Proposed Hornsea Three Offshore Wind Farm

Date: October 2018
By: Alan Cuttler / Neil Mackay / Ray Reynolds
Distribution:

AVIATEQ INTERNATIONAL LIMITED, UK 31ST OCTOBER 2018

Figure 8.8: Aviation flights within 9 nm of Hornsea Three during October 2017.

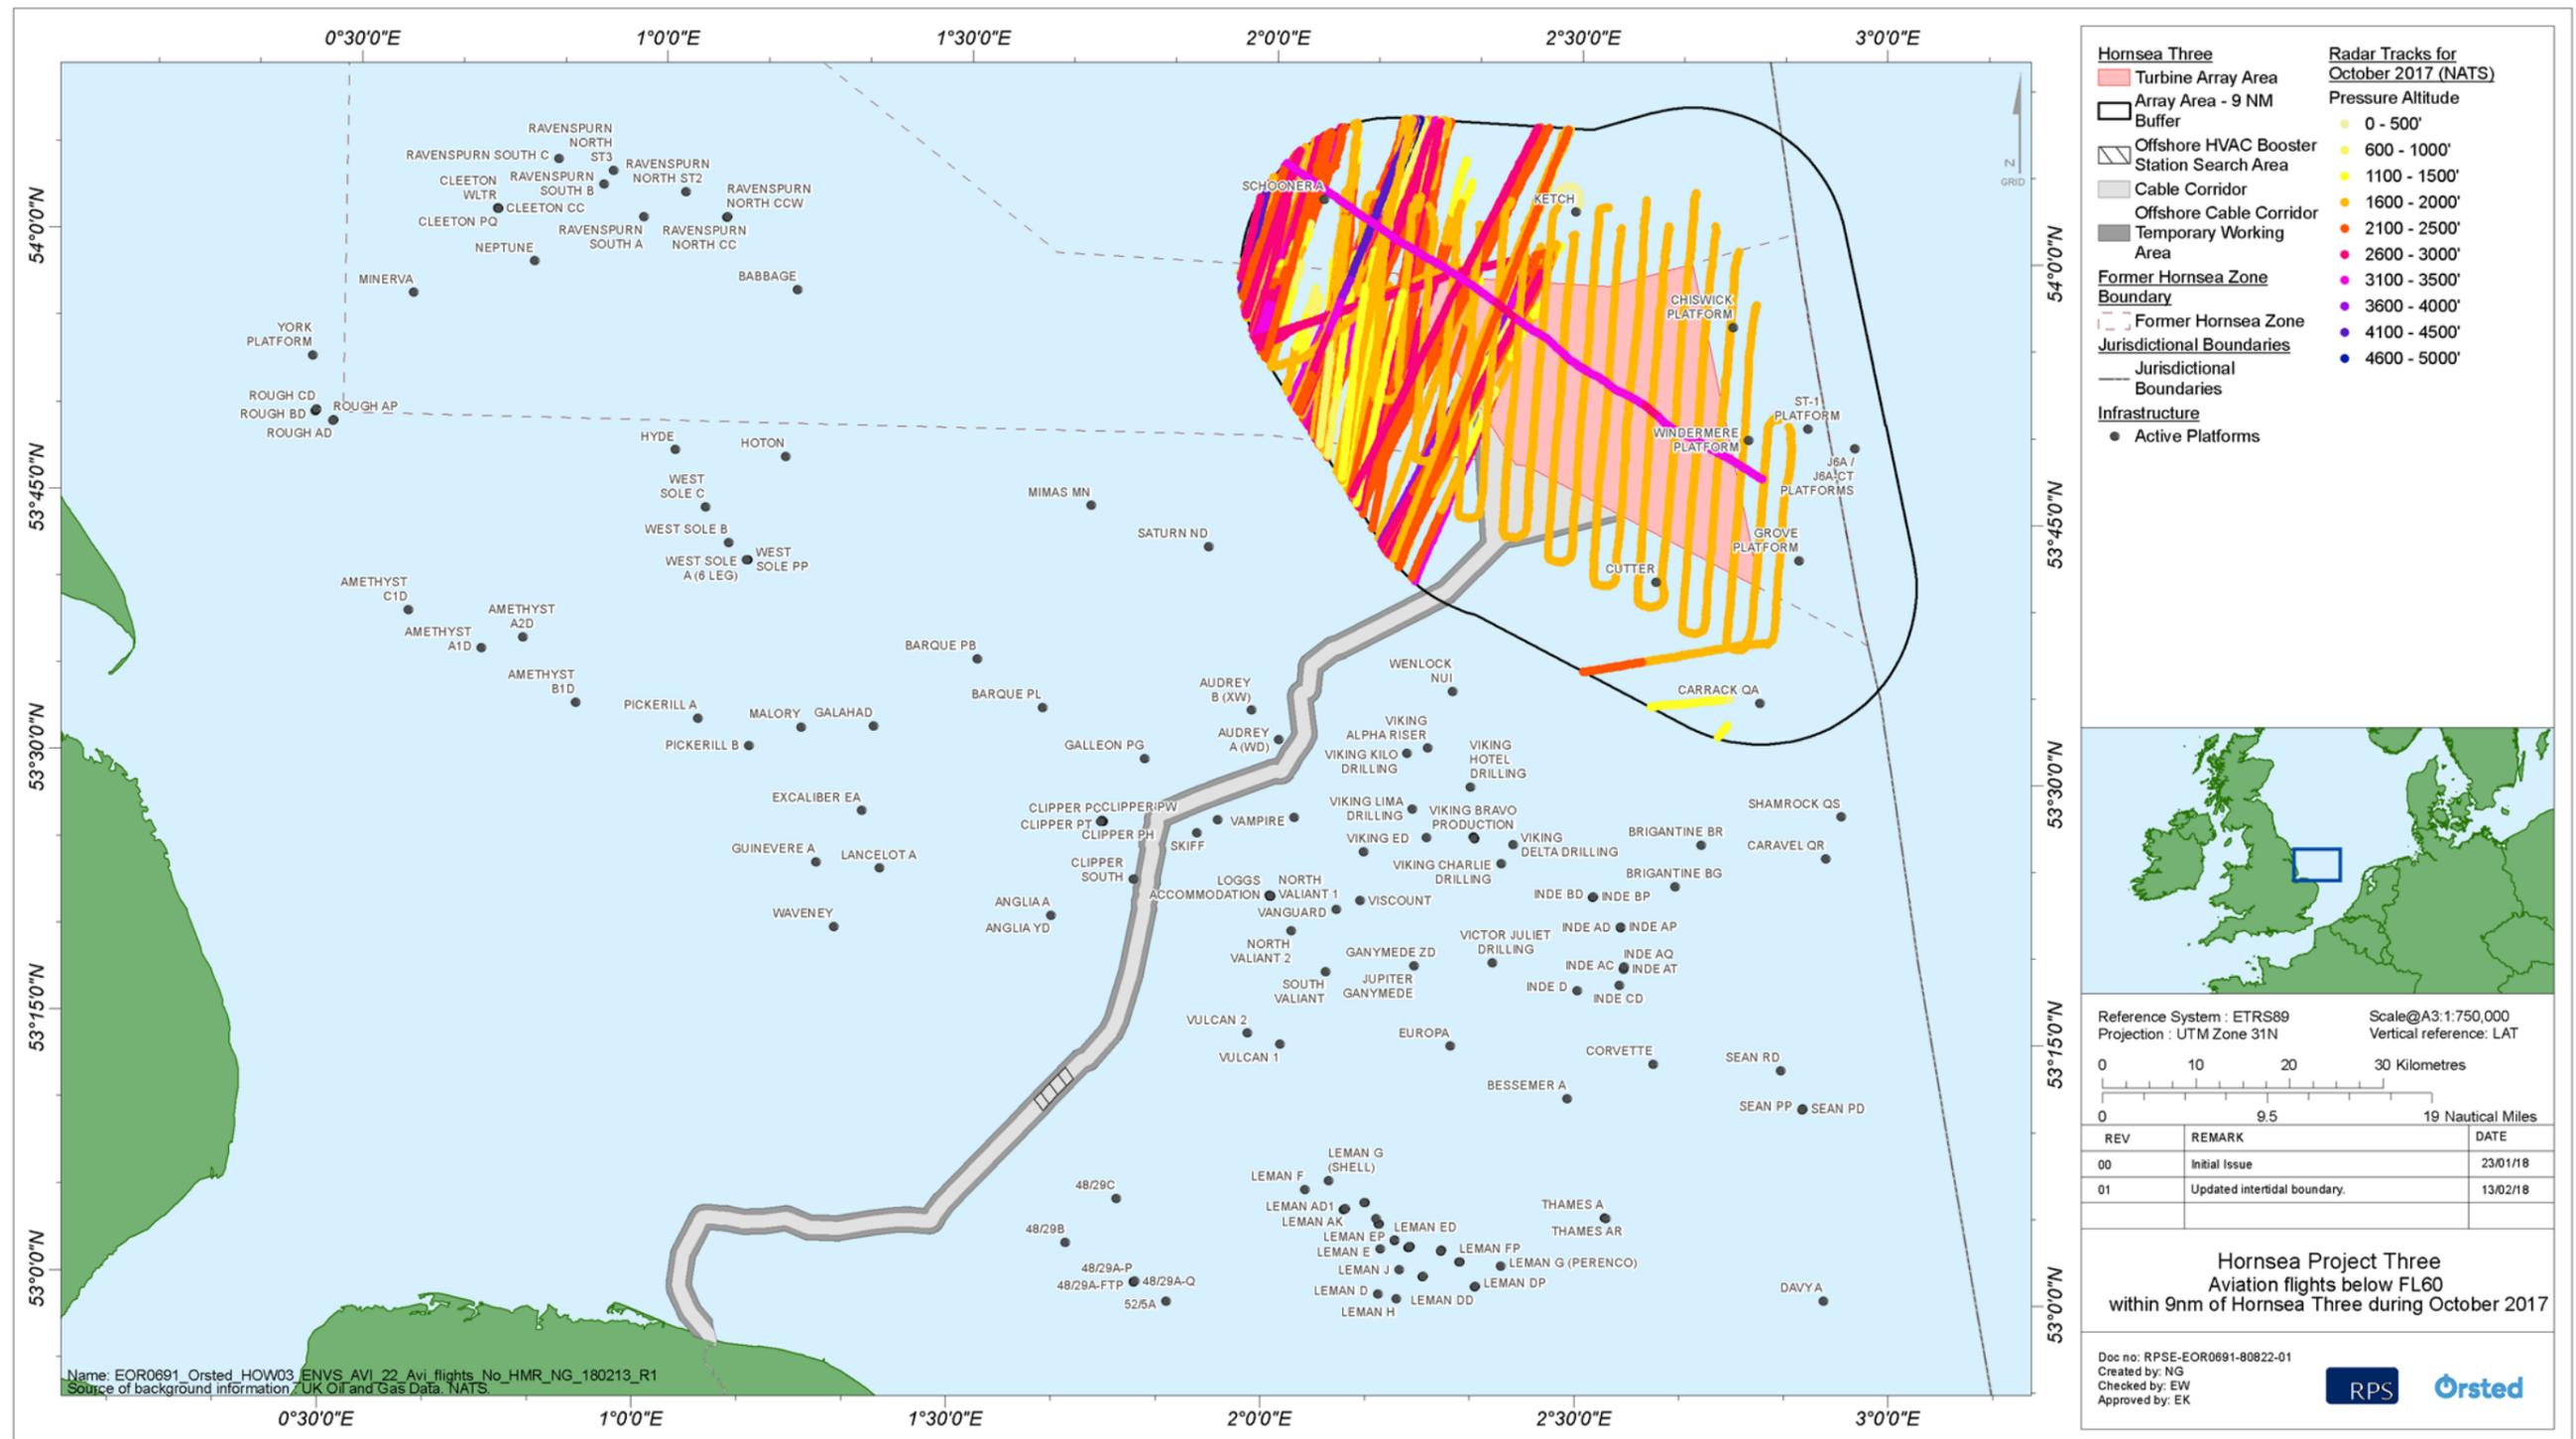
9.1 Reference Figure 8.8, Section 8.11, Chapter 8.11.2 of the ES and Slide #15 in the Hornsea Project Three Consultation Meeting held in Aberdeen, 10/10/2018 Power Point presentation. These figures depict aviation flights within 9 nautical miles of Hornsea Three during October 2017. They do not show the point of origin or the point of termination of the flights with Slide #15 stating that *no flights shown to Chiswick platform, J6A platform or Grove platform from Norwich or Humberside.*

9.2 The information is one year old and not representative of current activity. Records provided by Spirit’s current helicopter operator indicate that in 2018 up to the 22nd October 2018 there were 67 landings on the Chiswick platform from flights originating from Norwich and one to the J6A. The number of landings is quoted because the number of flights would be misleading due to multiple sector flights to Chiswick, Grove and J6A. In addition, these figures may not be representative of future demand as Spirit Energy may adjust the frequency of flights and subsequent landings in order to cater for increased or decreased demand. At the time of writing, for example, regular flights were being carried out for Spirit Energy to the Noble Hans Deul rig which was on project over the Chiswick location.
